ENGLISH HERITAGE

Our ref: P00403004

**Notifications under Circular 01/2001, Circular 08/2009 &
T&CP (Development Management Procedure) Order 2010
CHURCH OF ST PETER AND ST PAUL, THE STREET, RUSTINGTON, WEST
SUSSEX BN16 3NR
Application No R/77/14/PL**

REORDERING & EXTENSION:
ELEVATIONS AS PROPOSED

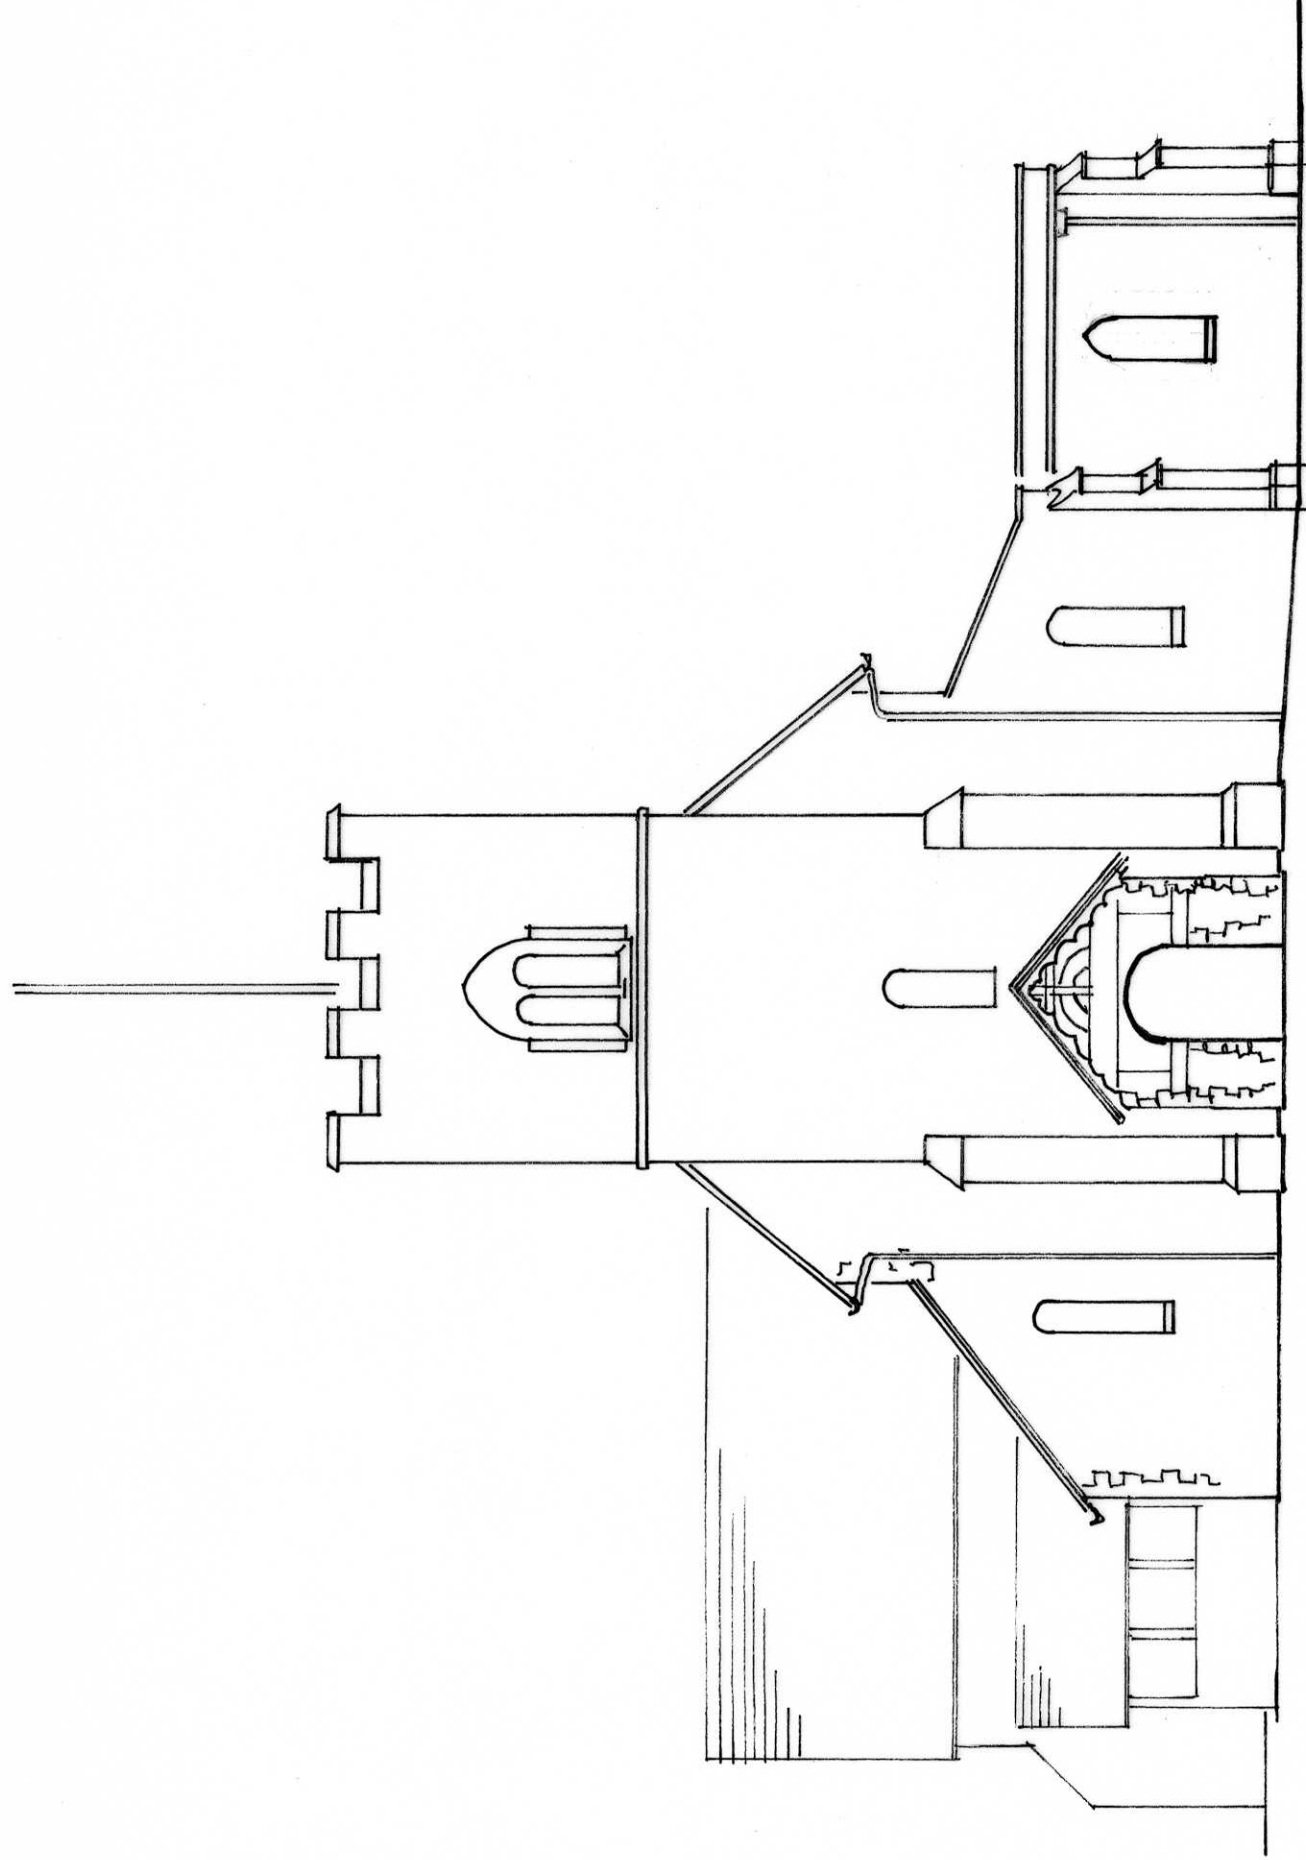
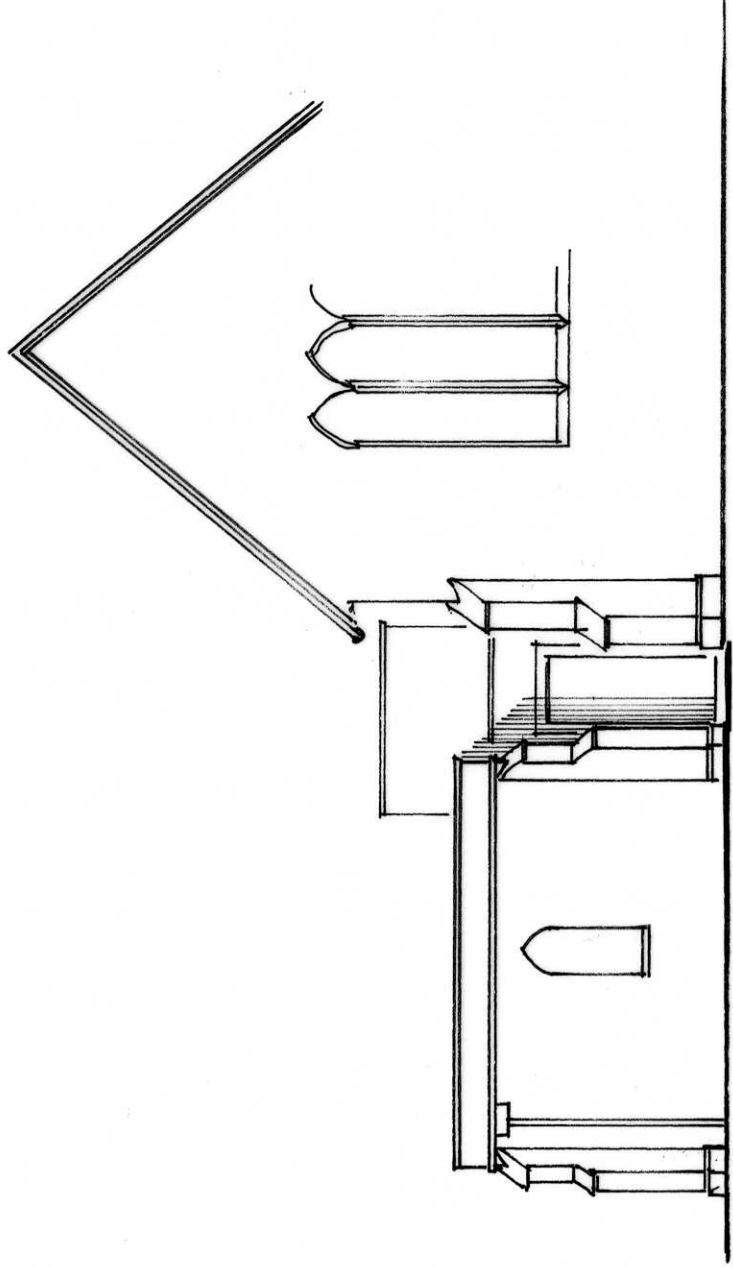
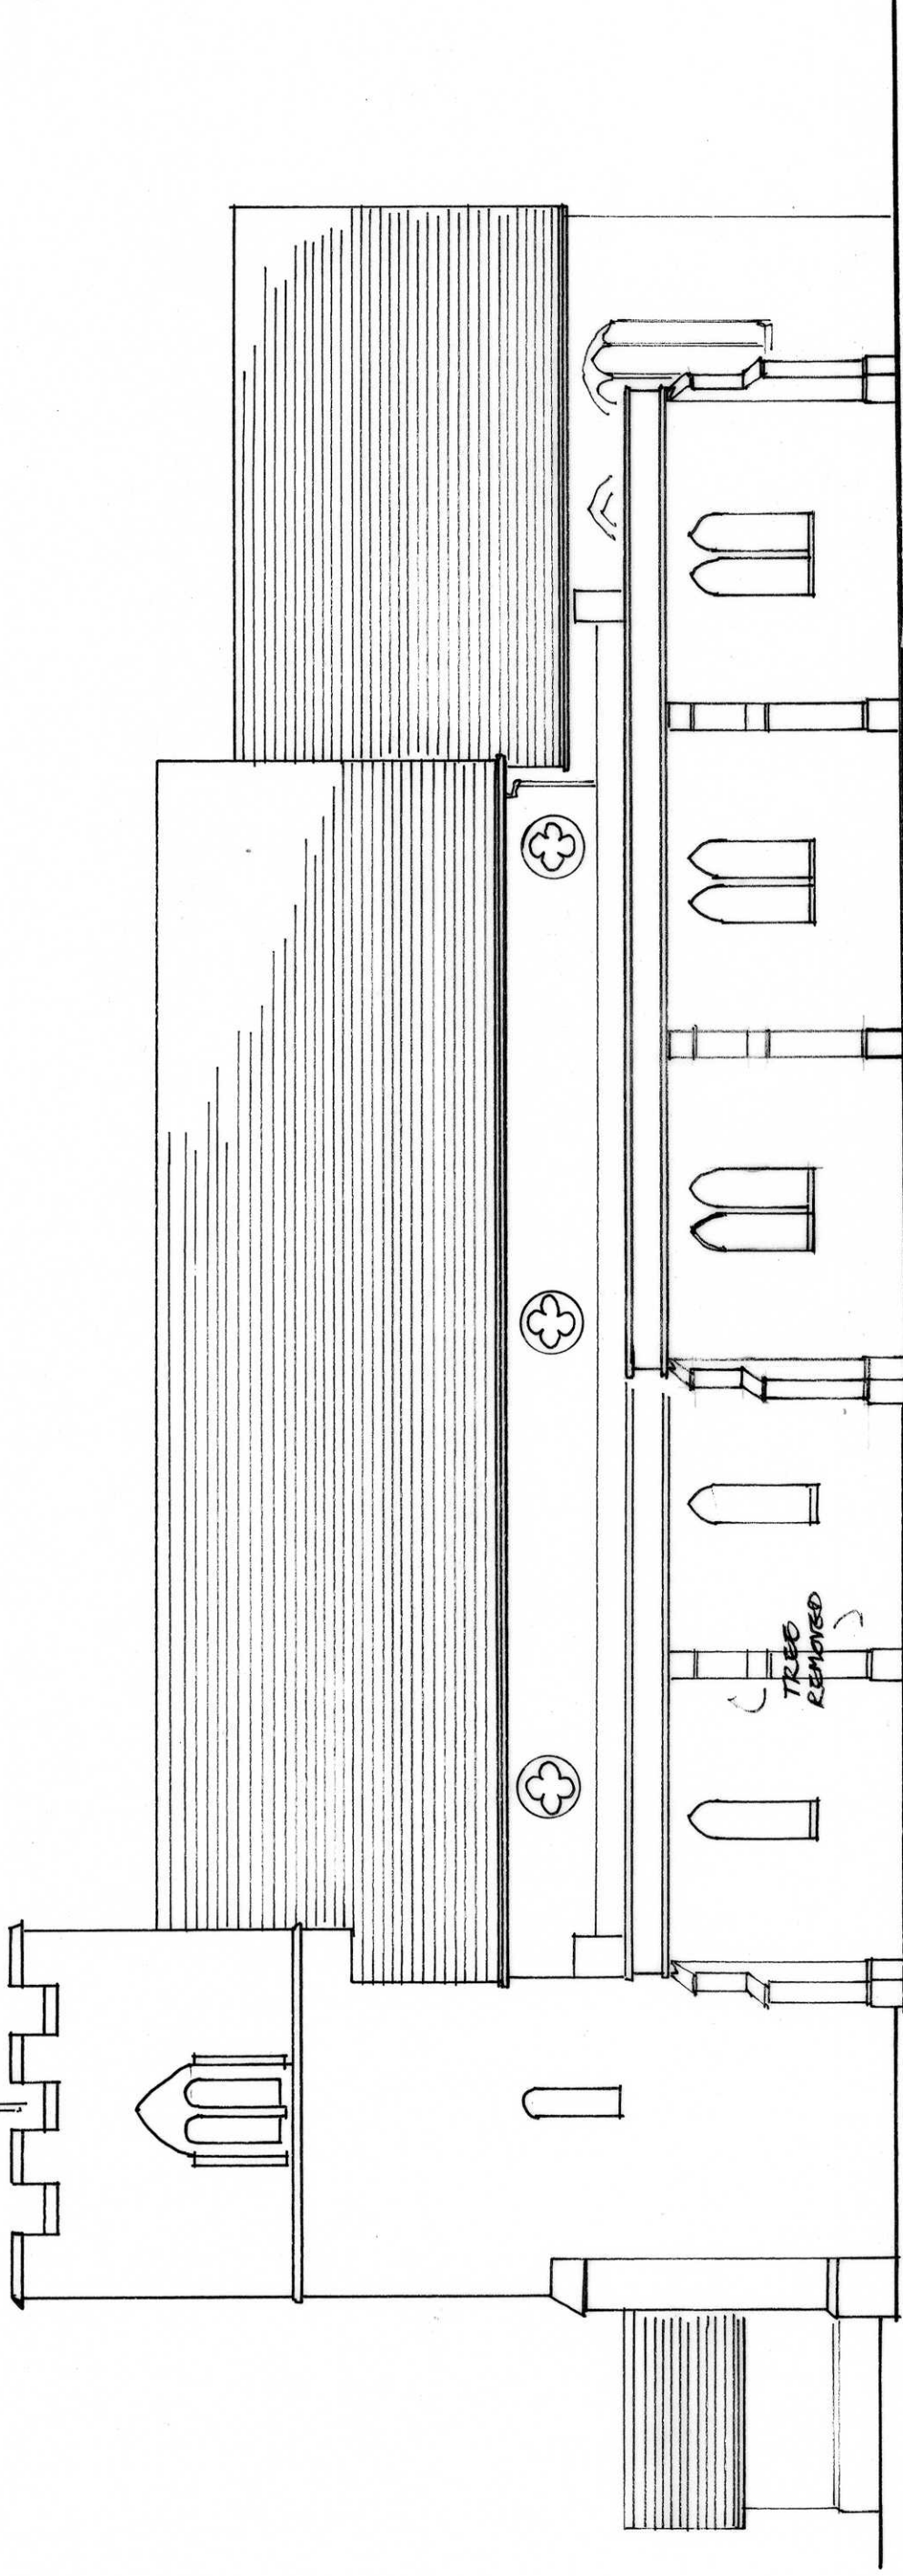
Should the local authority be minded to grant consent, we would advise that the detailing and materials of the scheme are carefully controlled and you may wish to impose a condition requiring a sample panel of the flintwork to be approved prior to the construction of the walls to the extension. There may be buried archaeology that could be affected by the new extension and any new drainage facilities. We would therefore advise that a condition is also applied requiring that no works should be carried out until the implementation of a plan of archaeological work has been secured in accordance with a written scheme of investigation which can either be submitted to and accepted by the County Archaeologist or the Diocesan Archaeological Adviser.

REORDERING & EXTENSION:
VESTRY & AISLE WALL AS PROPOSED

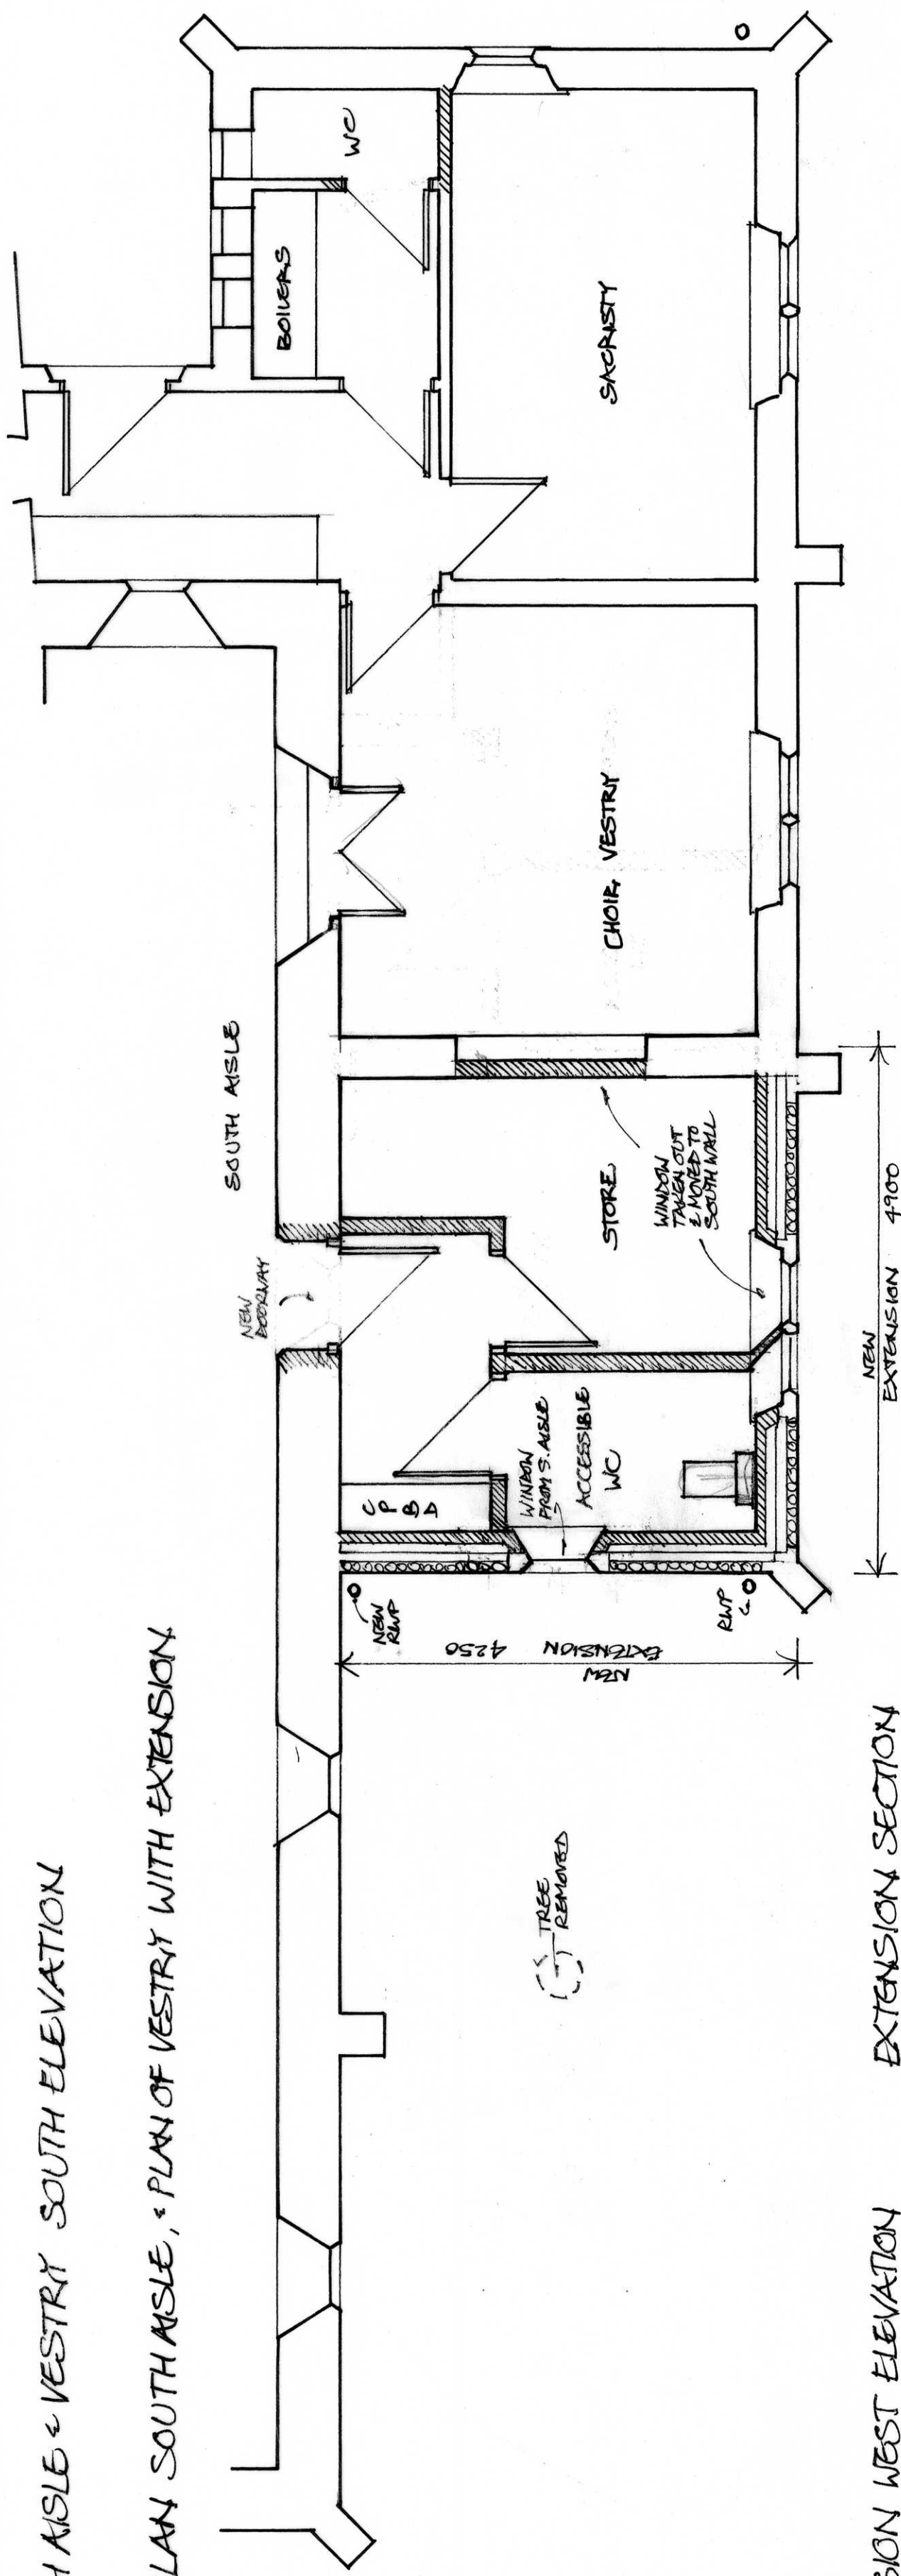
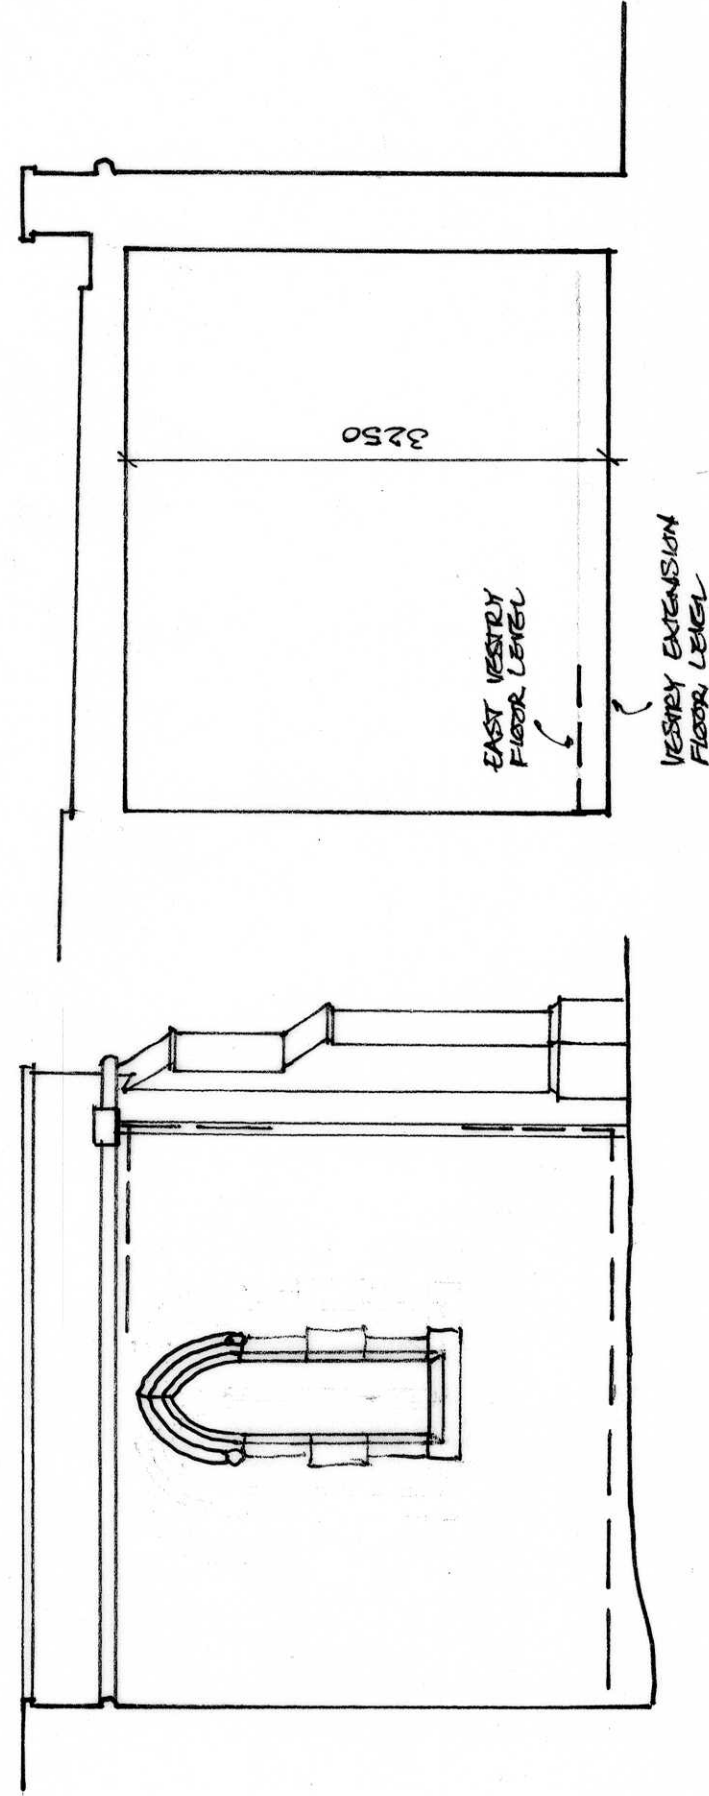
The scheme has not substantially changed since the previous application (local authority ref R/188/13) apart from the means of access to the extension which is now directly from the south aisle, utilising an existing window opening. It is explained in the submissions that this Victorian stained glass window would then be reused in the new extension. Whilst raising no objection in principle to the proposed extension, we note that no information on the significance of this window has been provided and the local authority may therefore wish to seek advice from the Victorian Society on this aspect as well as seeking clarification from the applicant on the justification for the changes to internal access arrangements.
